Tong Xie
Creative 9 / Chambers Coffee

**Request for Additional Information for Development Application DA 9431 at Sydney
Superyacht Marina**

Figure 4 | The proposed layout plan (Source: Applicant)

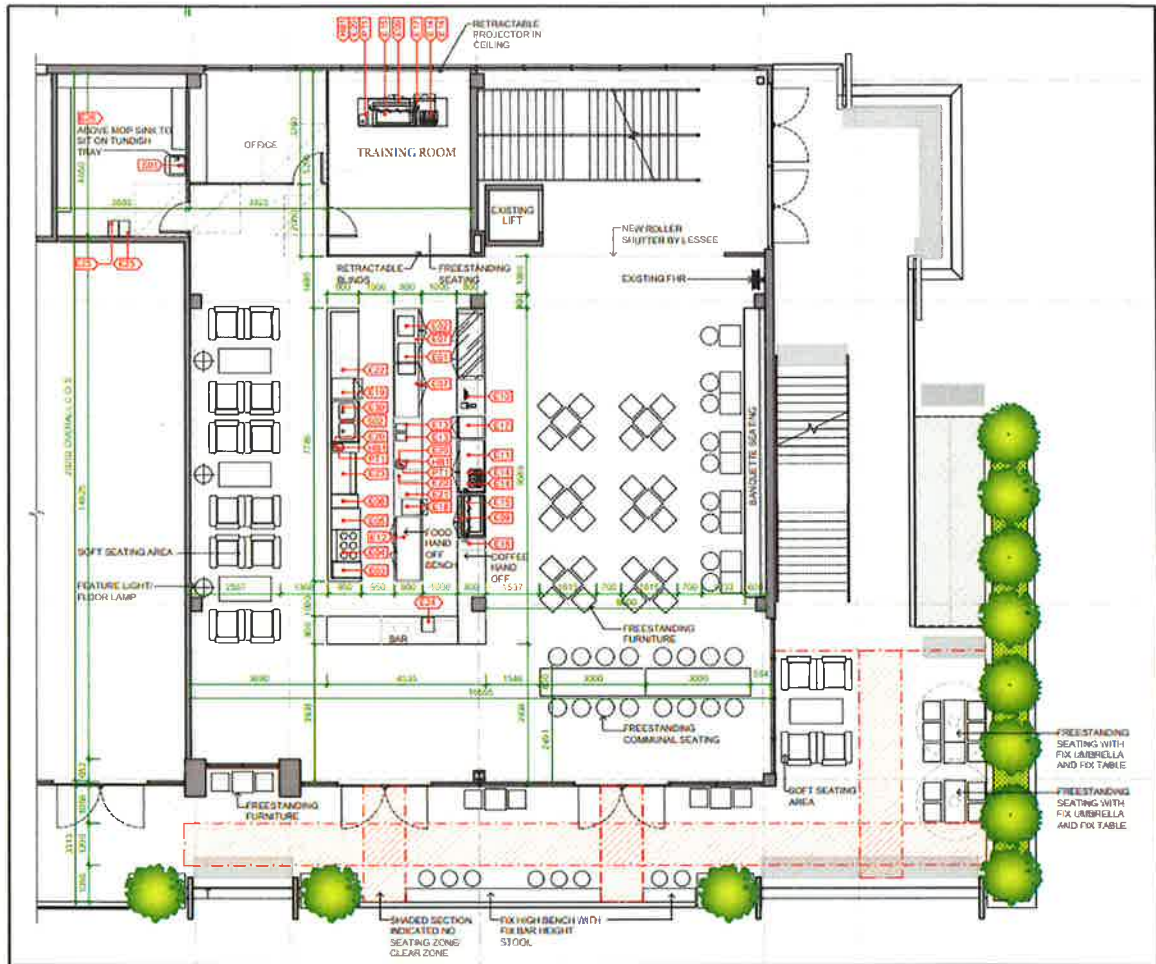
- The revised layout plan was provided to the Department on 21 September, 2018. The revised plan includes a proposed increase to the number of internal (+23) and external (+4) seats. Can you please update the Plan of Management to reflect these revised numbers.
- The Acoustic Assessment calculates noise levels on the premise that all windows and doors are shut at 10 pm and alternate mechanical ventilation is provided to the tenancy. Please include this arrangement in the Plan of Management.
